DECISION DELEGATED TO HEAD OF PLANNING

Application No: H12-0519-26 **Applicant:** Mr & Mrs K Schwarz

Proposal: Proposed Pitched Roofed Single Storey Extensions to Front & Rear of Existing Dwelling, Detached Single Storey Flat Roof Swimming Pool in Rear Garden

Location: Harecroft Lutton Bank Lutton

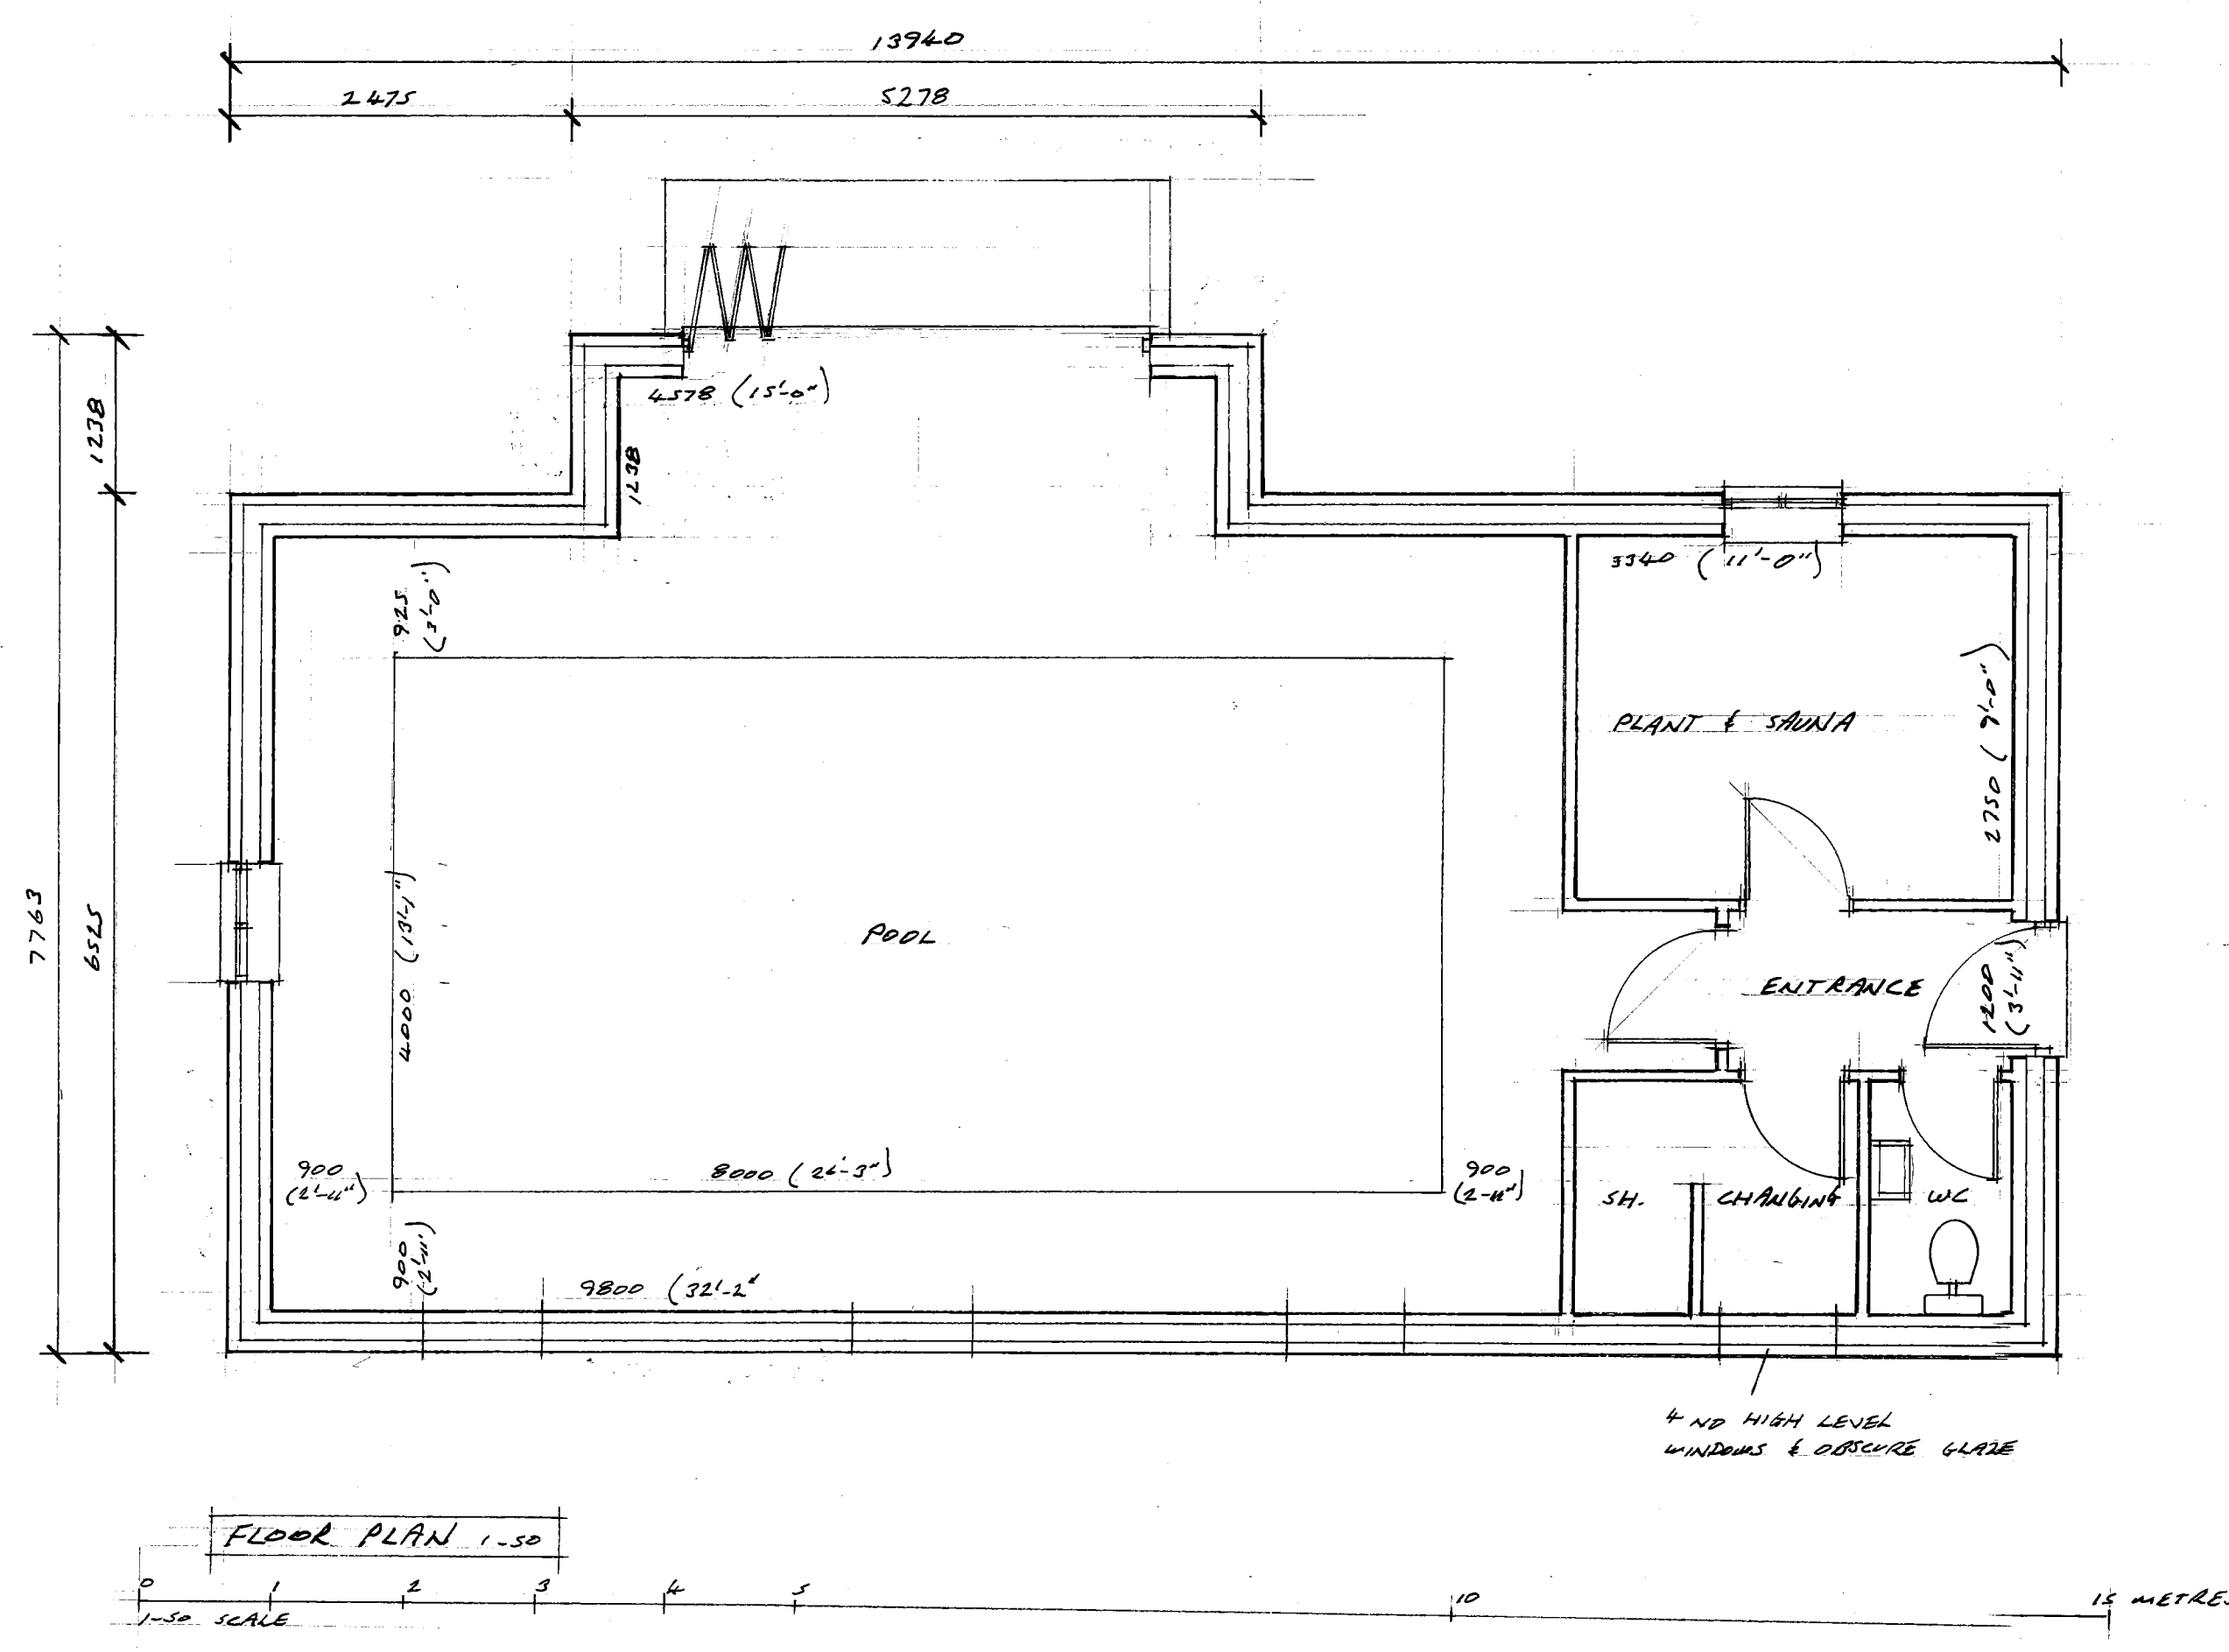
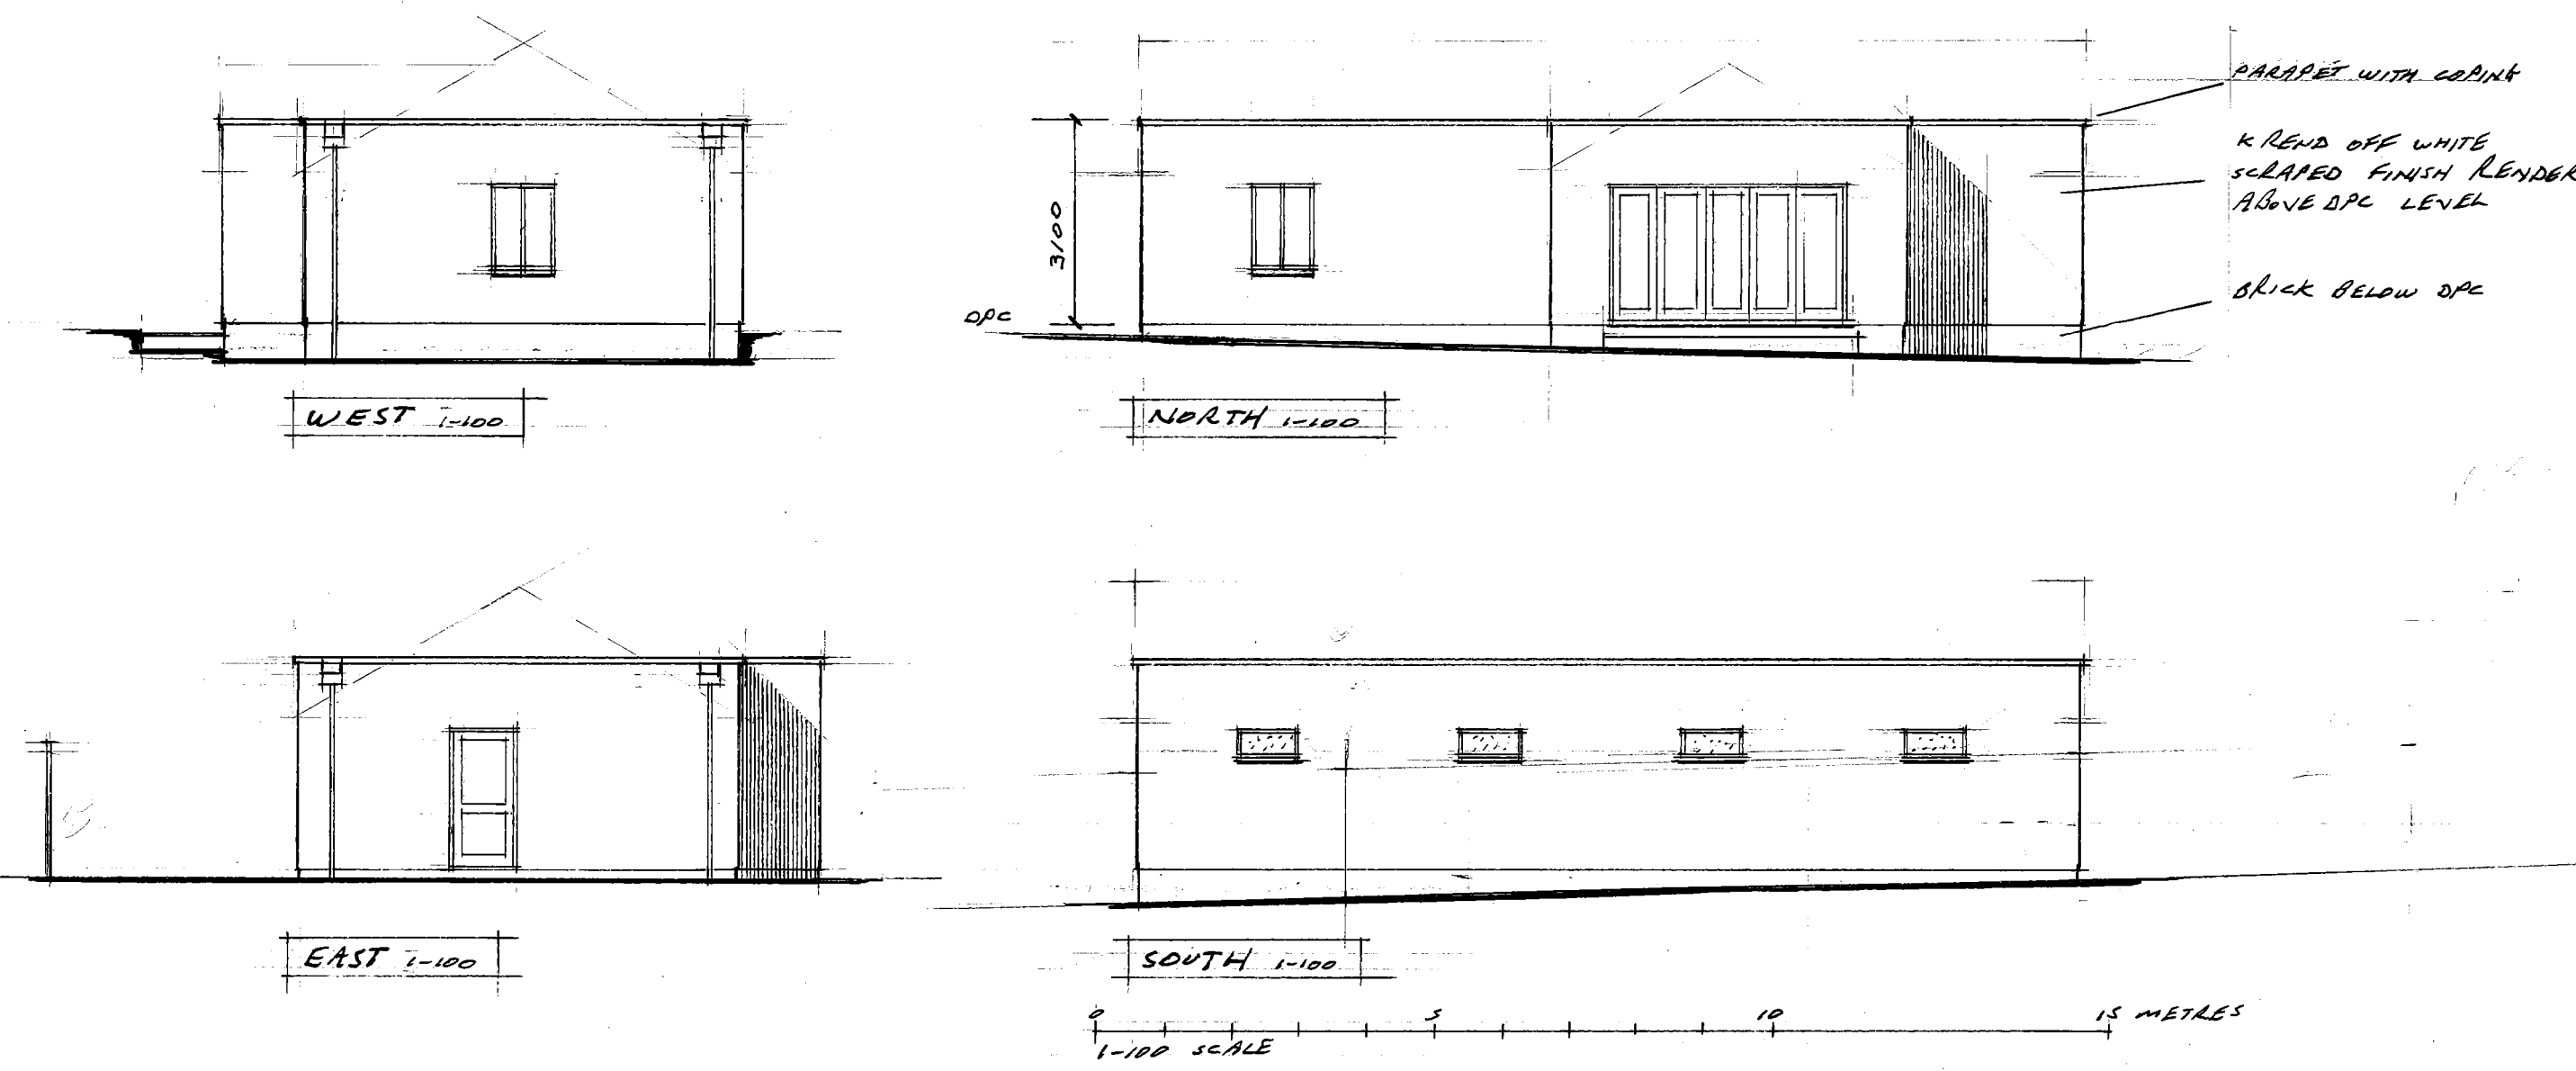
The submitted aerial imagery shows the land features mowed grass. Mowed grass is not indicative of residential curtilage. Within the aerial imagery pre-2020 available, there are no domestic accoutrements present on the land. The area appears to be simply laid grass. There is nothing before the Council to suggest that the land is part of the curtilage of the dwelling on the strength of these images. Circa 2021, an outbuilding appears on the land in the aerial imagery. However, said garage never received consent from the Council, and no application was made.

On this basis, the proposed pool is partially outside of the defined curtilage. Accordingly, the application cannot be processed as a householder application, as a change of use element would be included in the proposal.

No case for the need for an extension to the domestic curtilage has been provided. The desire to have an additional outbuilding is not a functional need, nor a development which one would anticipate must be in the countryside. Alternative schemes which would provide the accommodation within the curtilage have not been provided. On this basis, it is considered that need for the extension has not been adequately demonstrated. The proposal would therefore be required to demonstrate suitable benefits to the area, in line with Policy 1.
